# Cummeennabuddoge Wind Farm

Technical Note - Habitat Review

FuturEnergy Ireland

March 2024

Figure 8-2
Habitats mapping
Map 1

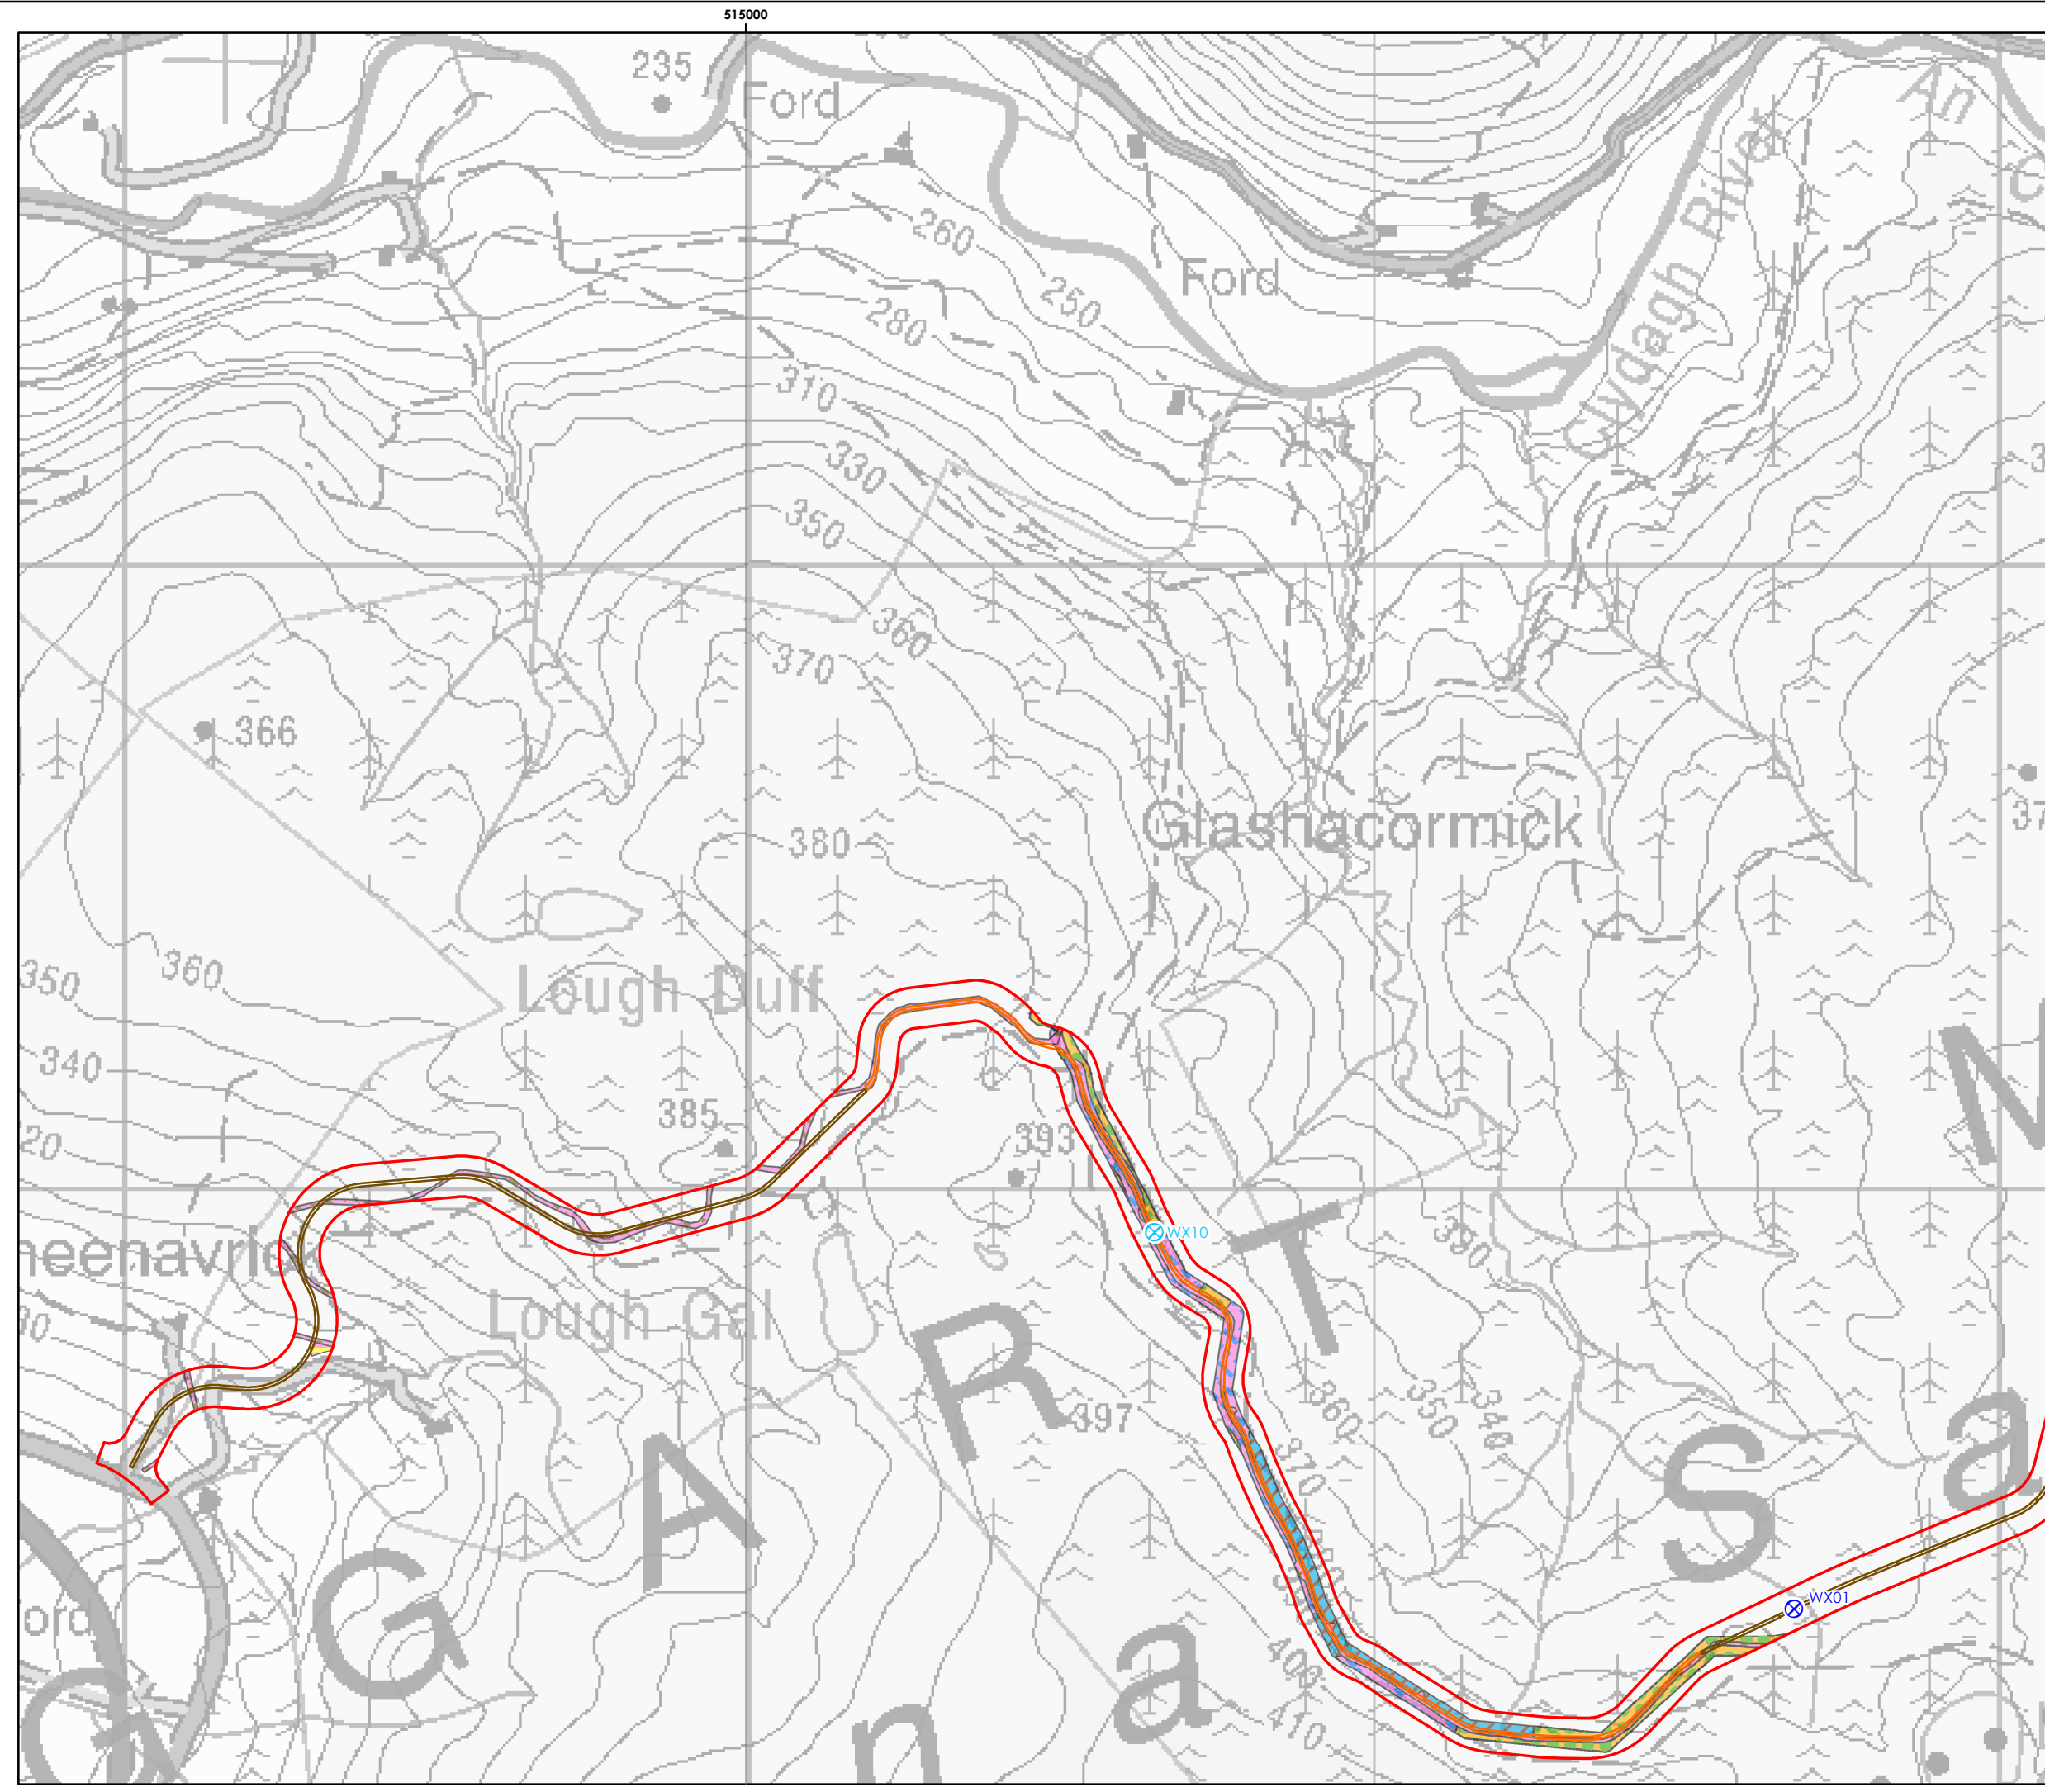
#### 3.1 Sheet 1 – Western access

The original habitat mapping provides little information for the western half of this sheet. However, the majority of adjacent habitat here is **WD3** mature conifer plantation, except near the western end where there is much **WS5** recently-felled conifer plantation. Within 100 m of the access route, but not close to it, there are some patches of rather poor **HH3** wet heath, dominated by purple moor-grass *Molinia caerulea* and heather *Calluna vulgaris*, and often with western gorse *Ulex gallii*. Aerial photography shows pale patches within the plantation close to the access route, but these are just poorly-grown conifer plantation (on ground that is evidently too wet and would be **HH3** wet heath without the trees).

At the extreme western end, the access route passes through a block of **WD1** semi-mature ash *Fraxinus excelsior* plantation, and beside the old road at the very start of the access route there is a thin band of **WN6** wet willow woodland (of grey willow *Salix cinerea* with mosaic wet and drier ground flora, and a few larger willows on a historic boundary).

A more substantial forest ride crossing the access track is poor quality **HH3** wet heath northwards, and southwards contains much pooled water with sphagnum. Within 100 m of the access track, but not close to it, there is a substantial **FL2** oligotrophic standing water, with peripheral **HH3** wet heath, **PF2** poor fen/flush (with soft rush *Juncus effusus* and sphagnum) and **GS4** species-poor purple moor-grass wet grassland.

A small patch of HD1 dense bracken noted in the previous habitat mapping is no longer present, having been destroyed by clear-felling operations.

The dominant habitats within 100 m are **WD3** mature conifer plantation (much as previously mapped) and **WD5** clear-fell (the zone of which is currently being enlarged). The proposed new access track section (not following existing tracks) still runs through **WD3** mature conifer plantation.

The previous habitat survey mapped strips of mixed wet heath/blanket bog and scrub beside the existing access track. The habitat review found that scrub dense enough to refer to **WS1** scrub (comprising grey willow and young conifers) is limited, and the open habitat strips are best classed as **HH3** wet heath on the east/north side of the track, and mainly as **PB2** upland blanket bog on the south side. The wet heath is disturbed in places, appears species-poor with purple moor-grass dominant, and often has scattered grey willow or young conifers. The blanket bog has a similar flora but less scrub and appears to be bog from the obvious deep peat often visible at the cut face next to the track. Much of the forestry west of the track here appears to be on former blanket bog. The open bog strip is undoubtedly adversely affected by the planted trees, track and drains – ideally it would be classed as degraded bog to highlight its lower value, but there is no option for this under the Fossitt system unless it is cutover bog.

Figure 8-2
Habitats mapping
Map 2

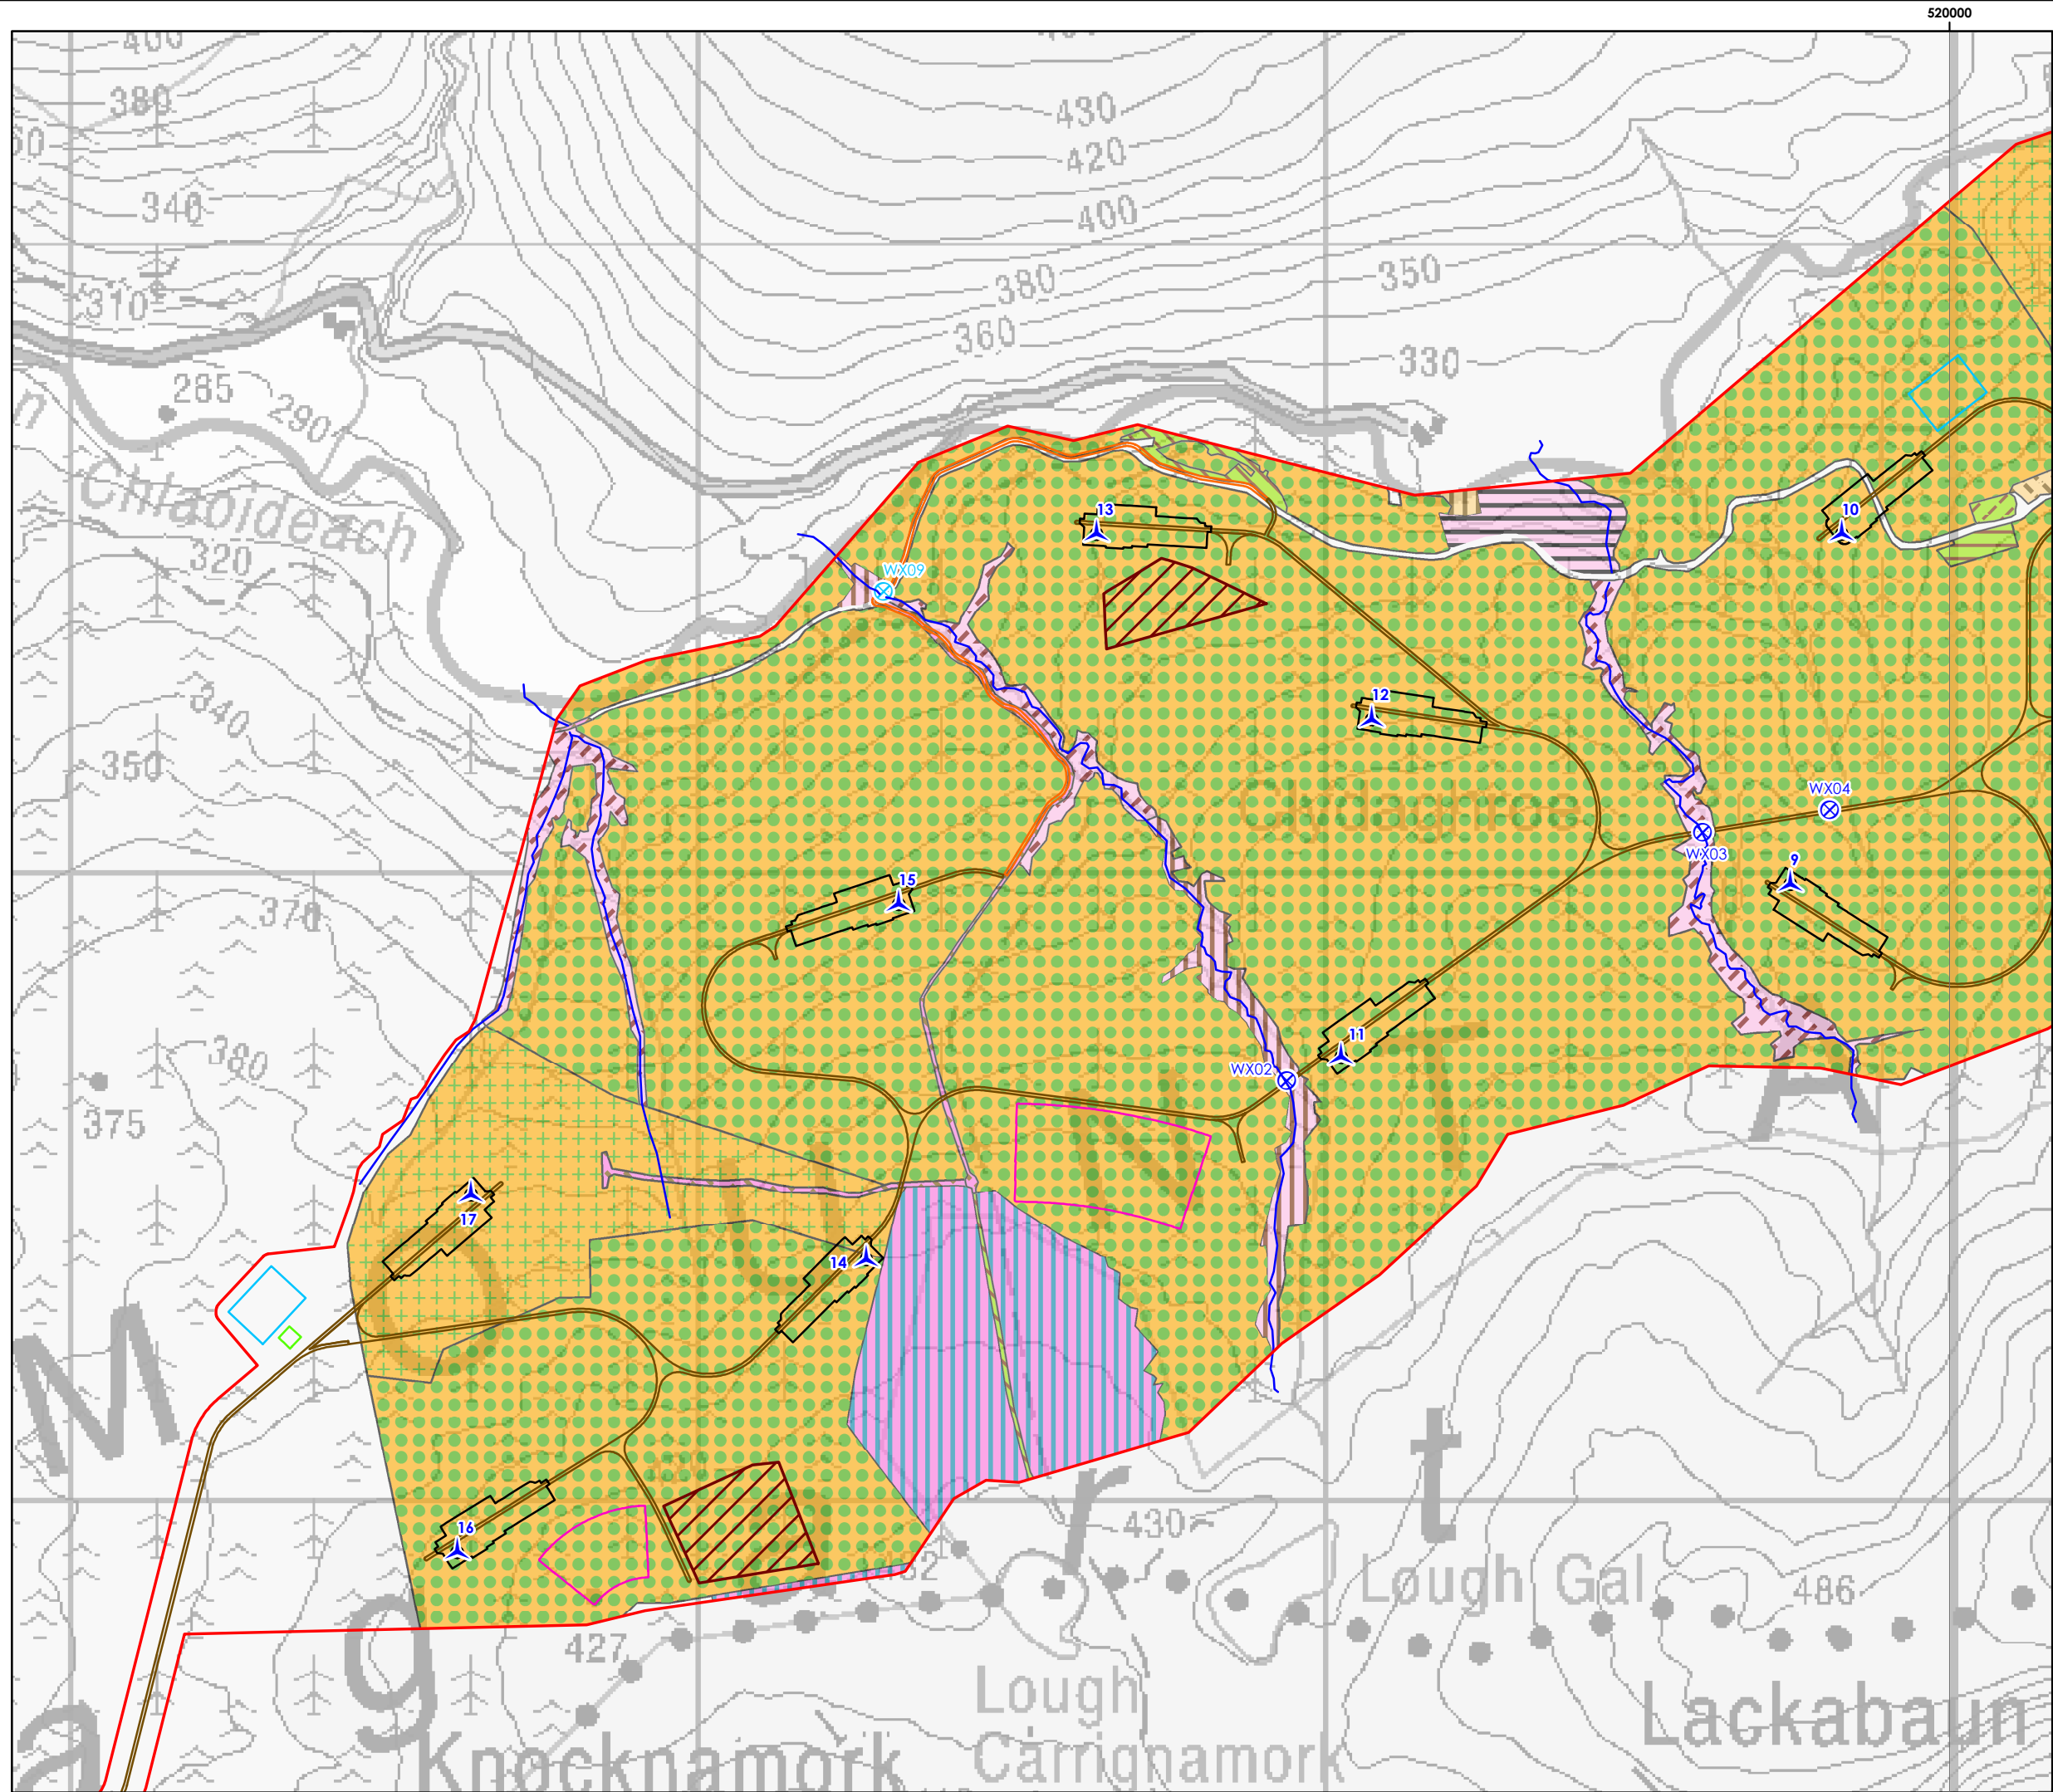
## 3.2 Sheet 2 – Western part of proposed turbine layout

The majority of this area is still **WD3** mature conifer plantation (as previously mapped). The zone previously marked as WS5 clear-fell is now **WS2** very recent conifer plantation. There is also a small patch, unaffected by any infrastructure, of **WS2** recent broadleaved plantation. A ride within the recent plantation area appears to be **GS4** species-poor purple moor-grass, although some parts may be **HH3** wet heath; however, this strip is unaffected by any proposed infrastructure.

Between water crossings WX09 and WX02, there is a strip of stream-side vegetation which is beside or crossed by sections of existing or proposed access track. This was previously mapped as a mosaic of **HH3** wet heath, **GS4** wet grassland and **GS3** humid grassland in the downstream (northern) part, and a mosaic of **HH3/GS4** in the upstream (southern) part. This is still broadly correct, although some of the rushy vegetation is best classed as **PF2** poor fen/flush (because it is acidic with sphagnum and *Polytrichum commune*). Additionally, it would be possible to refine the habitat mapping – for example, for the stretch running parallel to the access track, the adjacent habitat is mainly **GS3** humid (moderately acid) grassland, and the **HH3** wet heath is confined to the opposite (east) side of the stream (and thus at no appreciable risk of impact). The **HH3** appears typical of the Site, apparently species-poor with dense and tussocky purple moor-grass.

North and south of water crossing WX03, there is another strip of riparian vegetation. The previously-mapped mosaic of **HH3/GS4/GS3** is again broadly correct, although the same points made in the previous paragraph apply. There are patches of **PF2** poor fen/flush closer to the stream, as well as small patches of **GS3** humid (acid) grassland (short-grazed and typically on the inside of meanders), and the **HH3** wet heath is found more on the valley slopes. However, to the south-west of proposed Turbine 9, the outer vegetation in this strip appears to be degraded **PB2** upland blanket bog, judging from a visible 'lip' of deeper peat. At the northern end of this strip of riparian vegetation, there is a large sloping zone of **HH3** wet heath (as previously mapped). Just north of proposed Turbine 3 there was previously mapped a small zone of ED2 spoil/bare ground, however this was not seen during this Site visit, and instead this area appears to be poorly-grown conifers on a wet heath flora.

There is a large zone of **PB4** cutover bog in this part of the Site, as previously mapped. It is not directly impacted by any infrastructure. Proposed Turbine 14 is immediately adjacent to it, within forestry. However, it may be possible to refine the habitat mapping following the proposed detailed survey at a later date – actual zones of removed peat appear localised to thin strips in the northern part of this bog zone, such that areas further from the cuttings might be classifiable as intact bog. That said, a cursory inspection of the bog surface away from the immediate vicinity of the cuttings suggested that it was quite species-poor and lacking in expected sphagnum species, and this may justify retaining this whole bog zone as **PB4** cutover bog.
